RIBBLE VALLEY
BOROUGH COUNCIL

Application for a non-material amendment following a grant of planning permission.

Erection of a marketing suite with associated car parking and landscaping and advertisement consent for two flagpoles and one V board.	
Reference number:	3/2018/1033
Date of decision	08/01/2019

Non material amendment to amend the location of the marketing suite and V Board previously granted under planning permission 3/2018/1033

1 SALES ARENA PLAN
1:200 @ A1

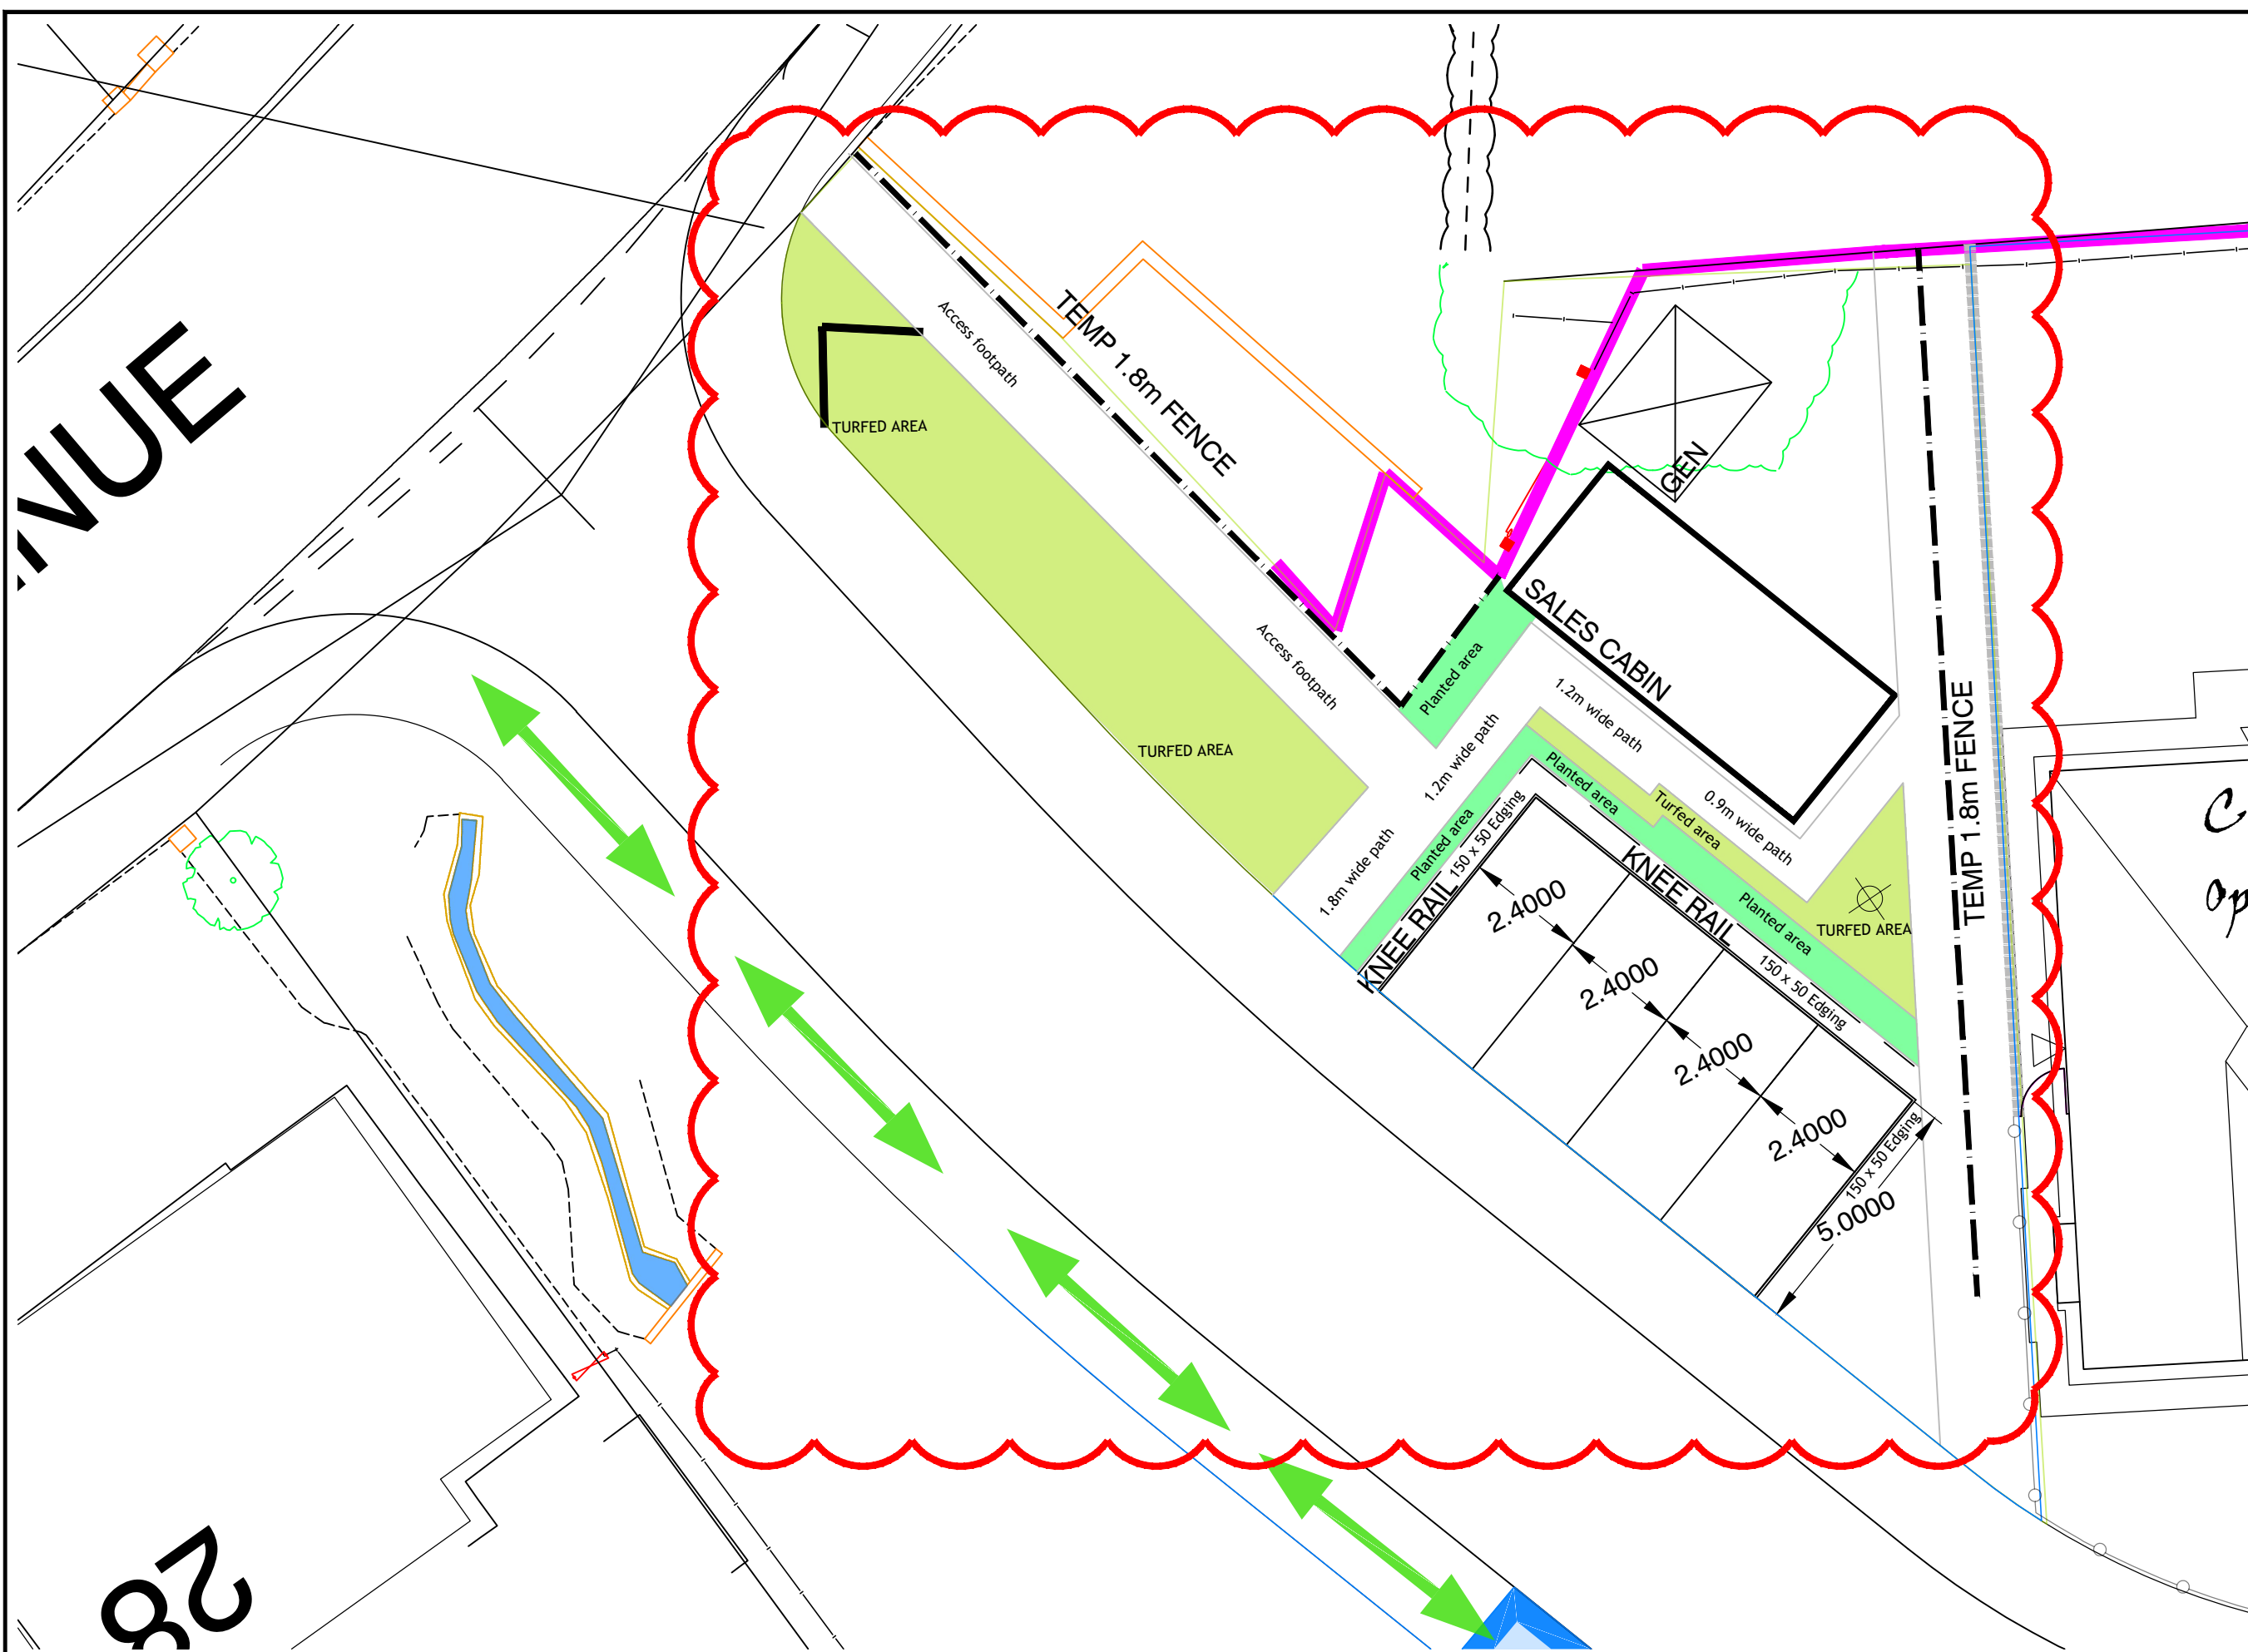
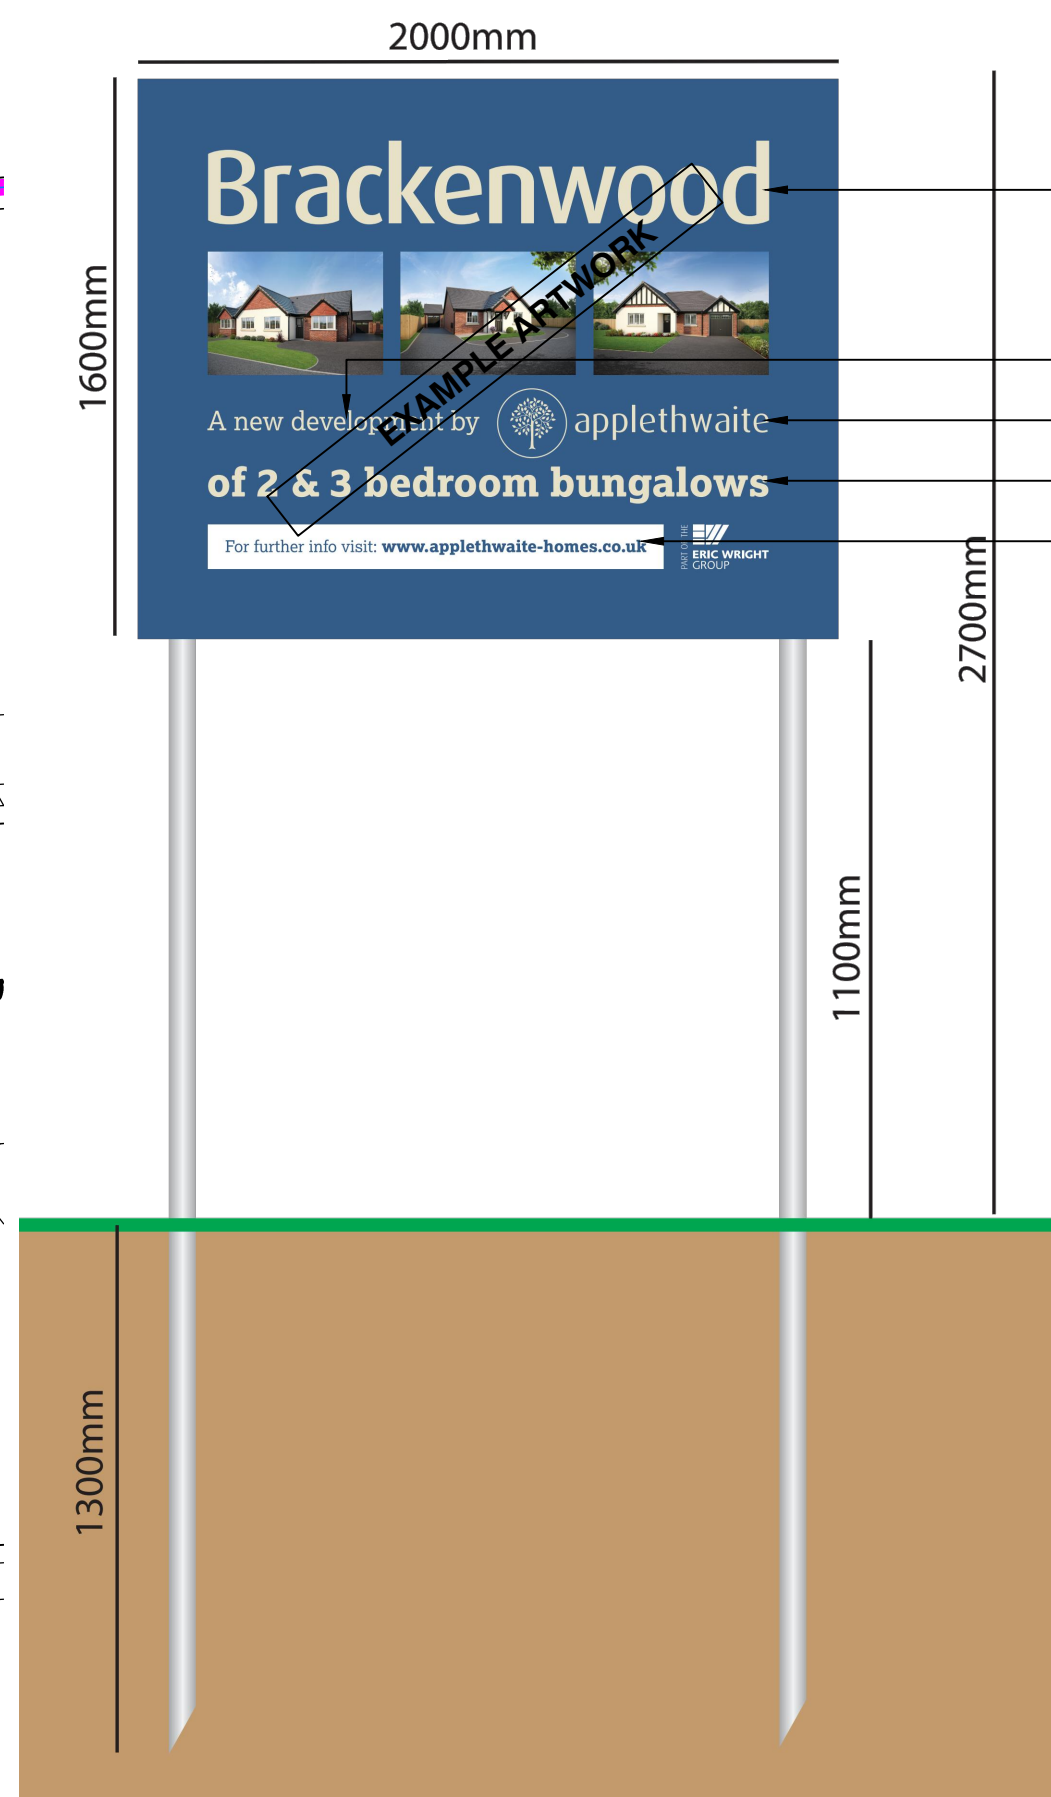
Change to location of the marketing suite and V Board

CLITH/SALES/01E
